WEST SUSSEX COUNTY COUNCIL CONSULTATION

TO:	Arun District Council - FAO: Ms Myer
FROM:	WSCC - Highways Authority
DATE:	30 November 2020
LOCATION:	Land East of North End Road and West of Church Lane Nursery Yapton BN18 0GA
SUBJECT:	Y/126/20/DOC Approval if details reserved by condition imposed under ref Y/18/20/PL relating to Condition Nos 6 - Construction & Environmental Management Plan, 9 - mitigation method statement re hedgerows, 10 - wildlife enhancement, 11 - landscaping, 12 - materials & finishes, 13 - screen walls & fences, 14 - Part M of Building Regs 2010, 16 - cycle parking, 18 - energy efficiency, 19 - electric vehicle charging and 20 - external lighting.
RECOMMENDATION:	More Information

West Sussex County Council, in its capacity as the Local Highway Authority (LHA), have been consulted on approval of conditions secured under Y/18/20 (6 x dwellings).

PROPOSED SITE PLAN
(1:100)

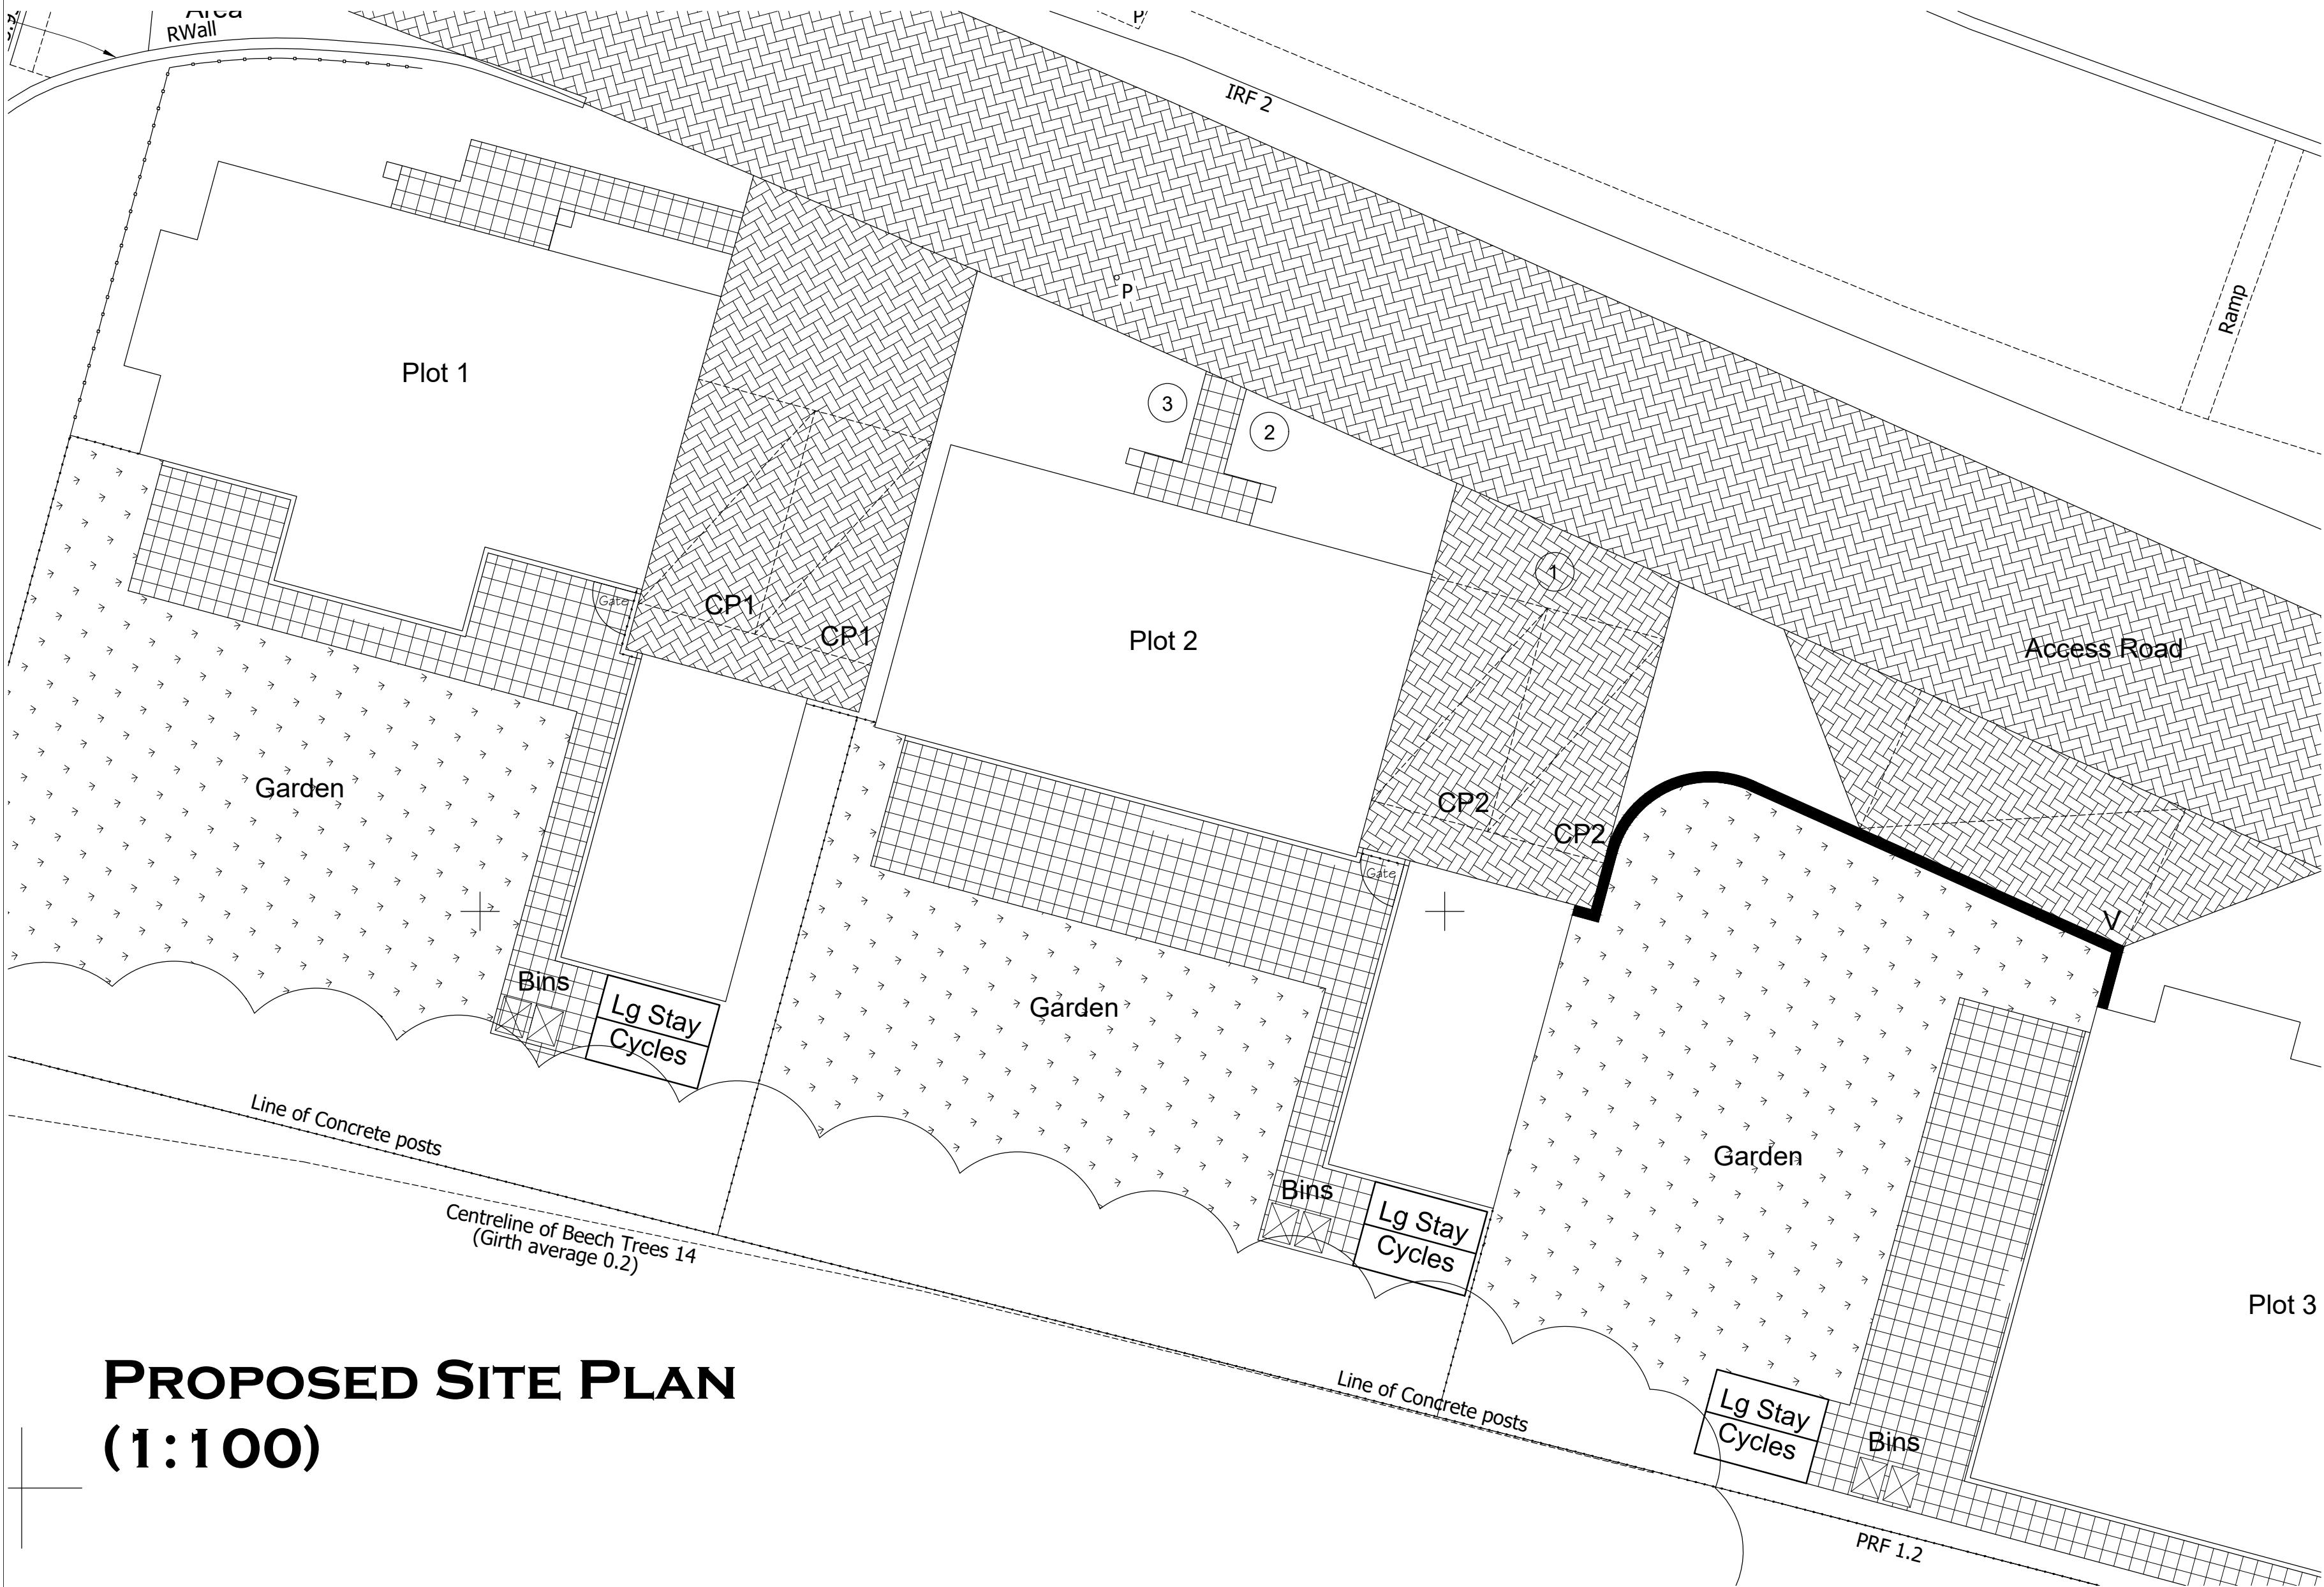
It is not clear to what layby the CEMP refers. Furthermore, on-street parking on this main 'B' road would not be an ideal arrangement. There does appear to be space within the site for some contractor parking and unloading of materials. The site plan within the CEMP is not legible. The LHA request further information in respect to the following;

- the anticipated number, frequency and types of vehicles used during construction,
- the method of access and routing of vehicles during construction,
- the parking of vehicles by site operatives and visitors (show on-site)
- the loading and unloading of plant, materials and waste (ideally show swept path tracking for vehicles turning within the site)
- the storage of plant and materials used in construction of the development,
- the provision of wheel washing facilities (indicate on site plan).

Details of the electric vehicle charging infrastructure and locations has been provided along with location for secure cycle storage per plot. The plans and details pertaining to the conditions 16 and 19 are acceptable.

Please ask the applicant for the additional information and clearer plan in respect to condition 6 and re-consult.
